Harnett County Government Complex
307 W. Cornelius Harnett Boulevard
Lillington, NC 27546

Re: Status of Repair Permit for 400 Wyndham Place, Fuquay-Varina NC 27526

An attempt was made to evaluate your property for the purpose of issuing a Repair Permit. The evaluation could not be completed for one or more of the following reasons.

OPERATIONS PERMIT

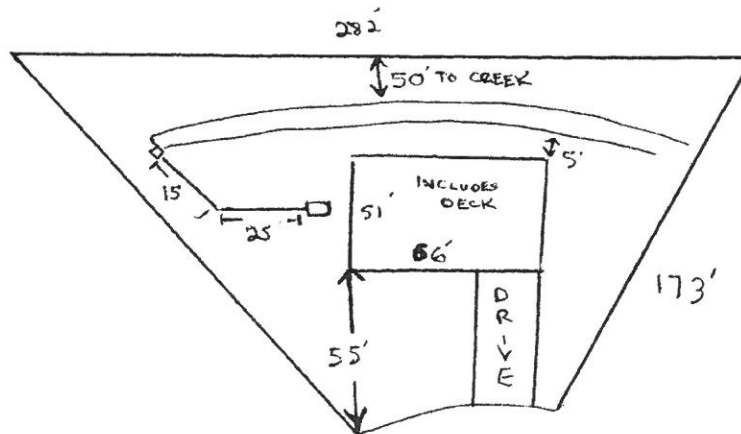
7. Other- Drain line appears to have obstructions inhibiting flow of septic affluent. Septic affluent surfacing at D-Box but no surfacing along two (2) 150ft drain lines. Multiple trees with roots along drain line route. Snake out or camera drain lines and attempt clearing out blockages. Contact septic contractor to inspect for blockage.
